WEST SUSSEX COUNTY COUNCIL CONSULTATION

TO:	Arun District Council FAO: Amber Willard
FROM:	WSCC - Highways Authority
DATE:	28 April 2022
LOCATION:	Land to South of Dukes Road, Fontwell, BN18 0SP
SUBJECT:	AL/39/22/OUT Outline application with some matters reserved (appearance, landscape and scale) for the erection 9 No. residential dwellings. This application is a Departure from the Development Plan.
DATE OF SITE VISIT:	N/A
RECOMMENDATION:	More Information
S106 CONTRIBUTION TOTAL:	N/A

Drawing 221528/TS/01 – Proposed Access Arrangements

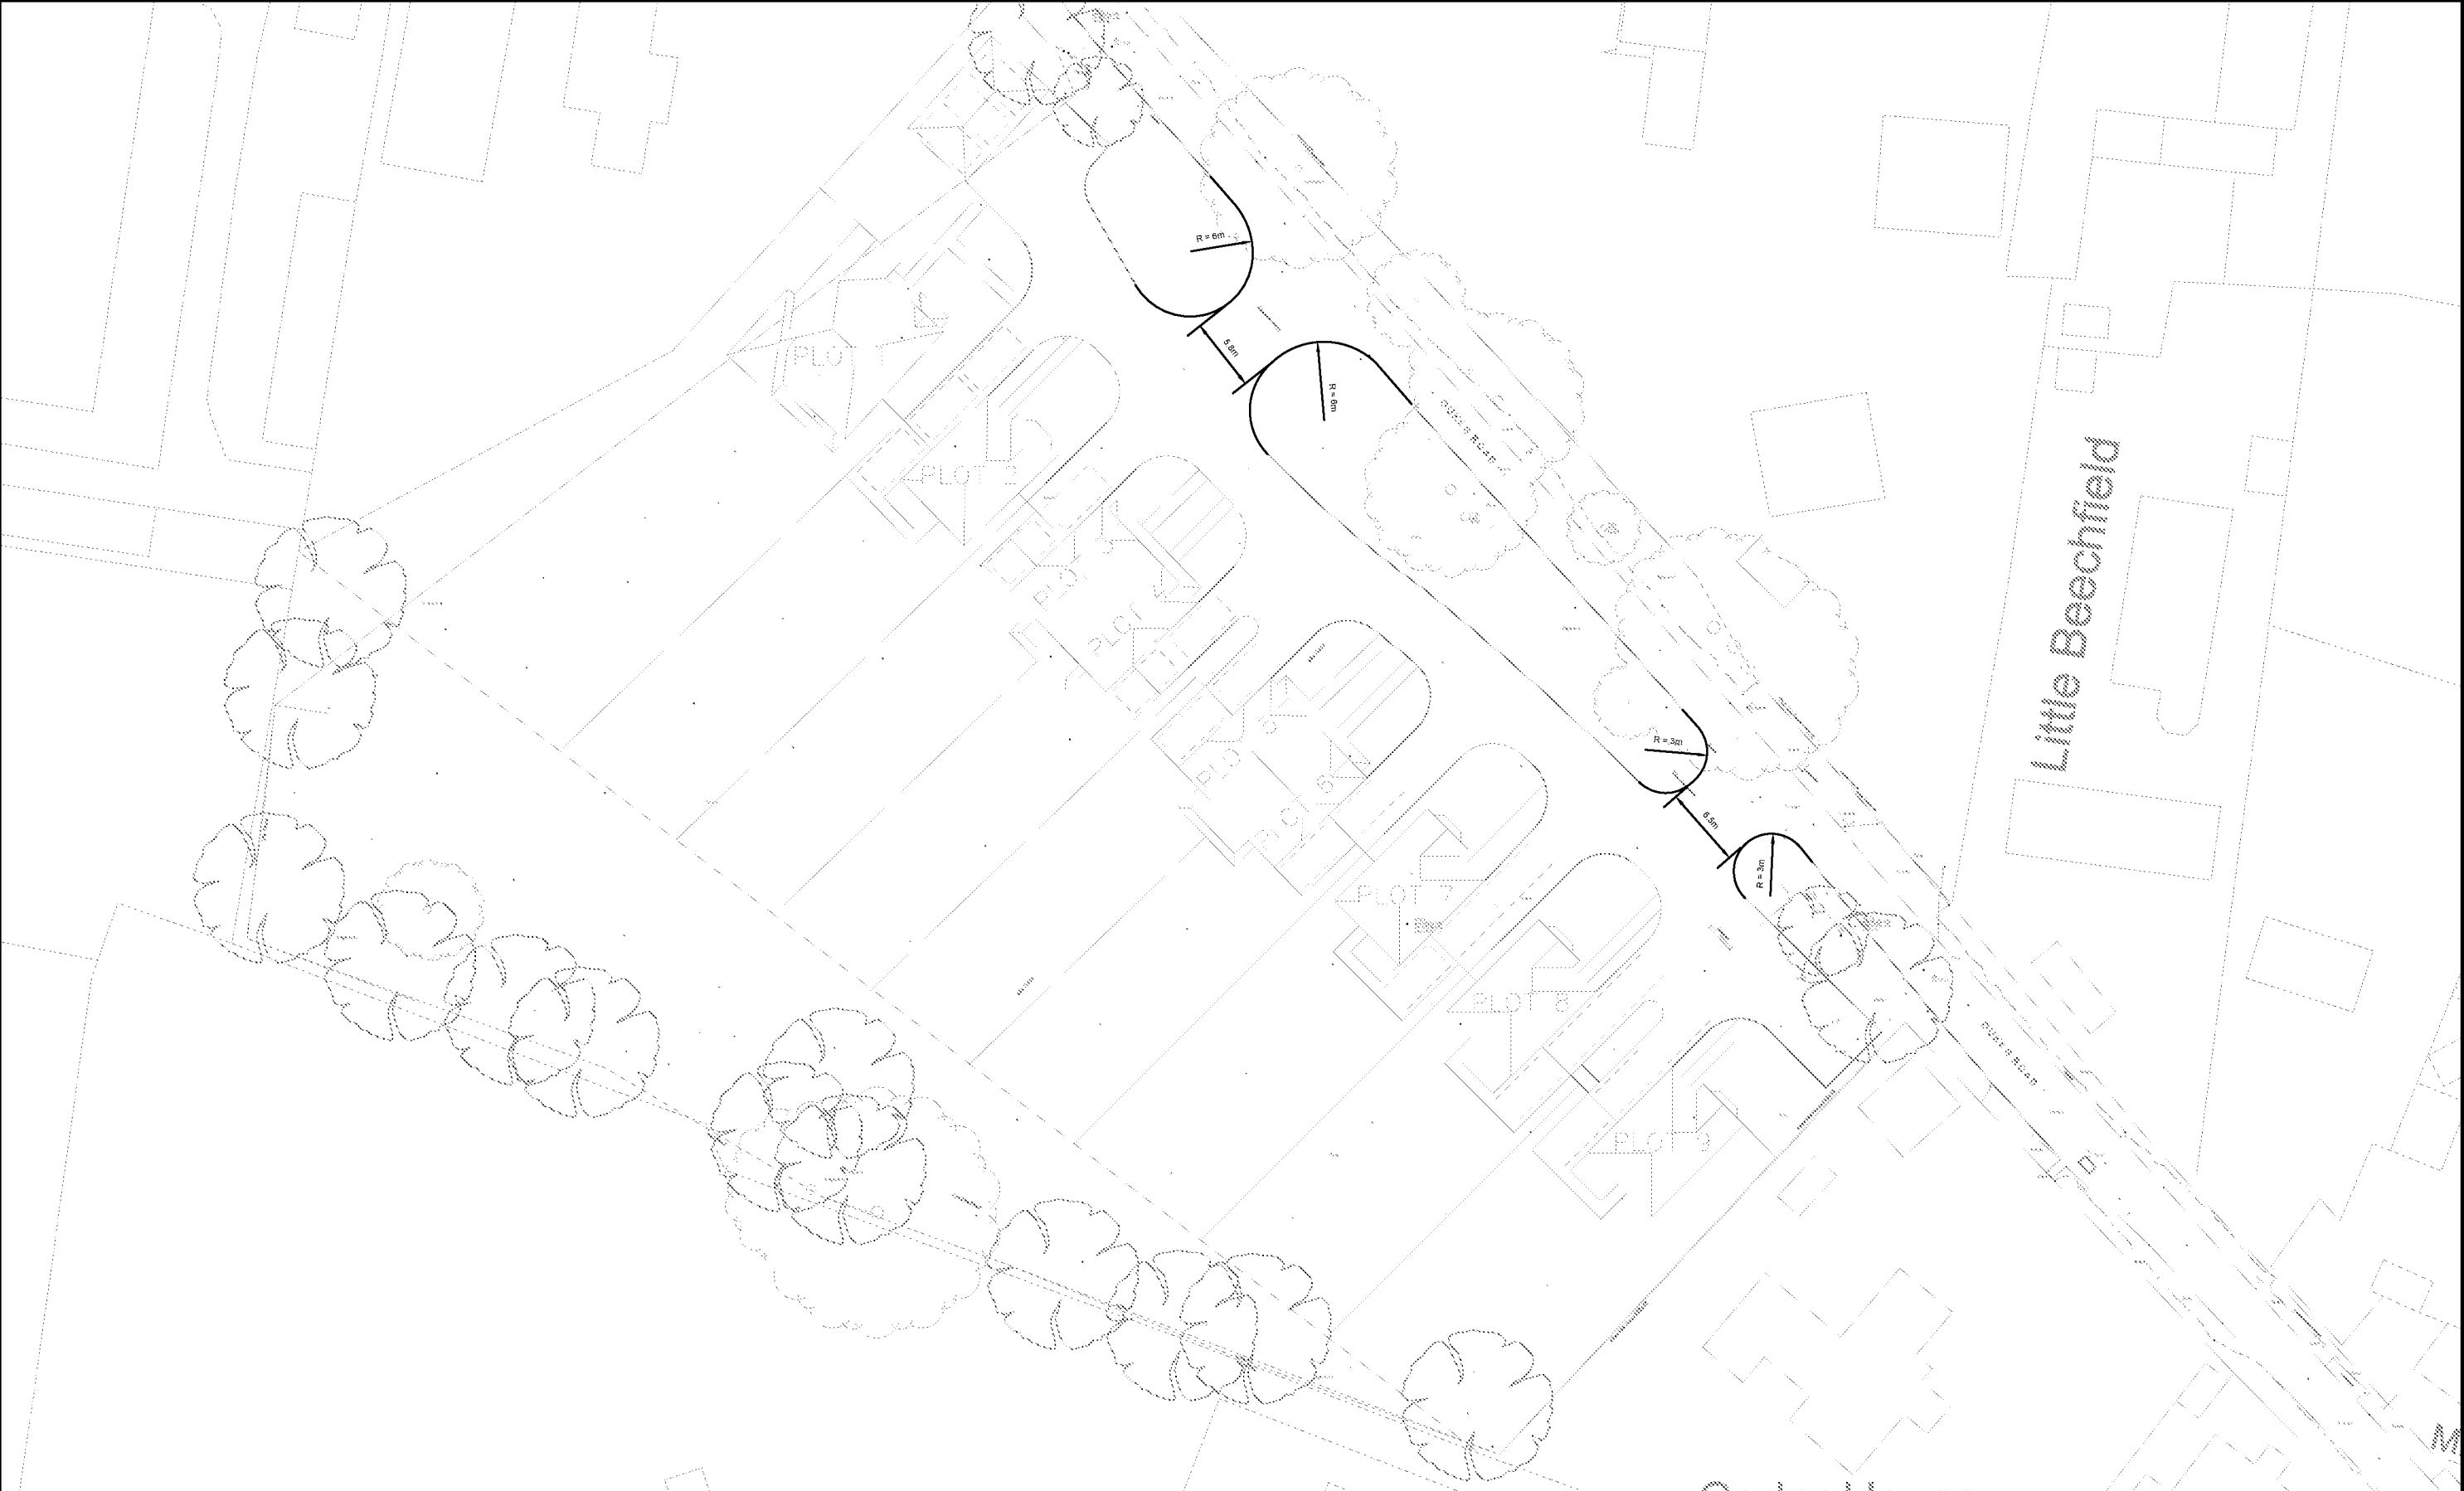
The applicant proposes two new vehicular accesses on Dukes Road. The Transport Statement has provided a vehicular visibility plan, with splays of 2.4m x 43m achievable in both directions for both proposed accesses. Whilst this would be acceptable for a 30mph speed restriction, Dukes Road is subject to national speed limit. The LHA recognises the rural and narrow nature of the highway in this location; however, the LHA requests that the applicant undertakes a seven-day speed survey to ascertain the 85th percentile speeds in this location. Appropriate visibility splays can then be demonstrated in accordance with this data.

In addition to the above, the Transport Statement states that servicing/emergency vehicles will utilise the new access road to serve the development. The LHA requests the applicant to demonstrate via swept path tracking that service vehicles, such as a refuse vehicle/fire appliance, can safely access and egress the site on to and from Dukes Road.
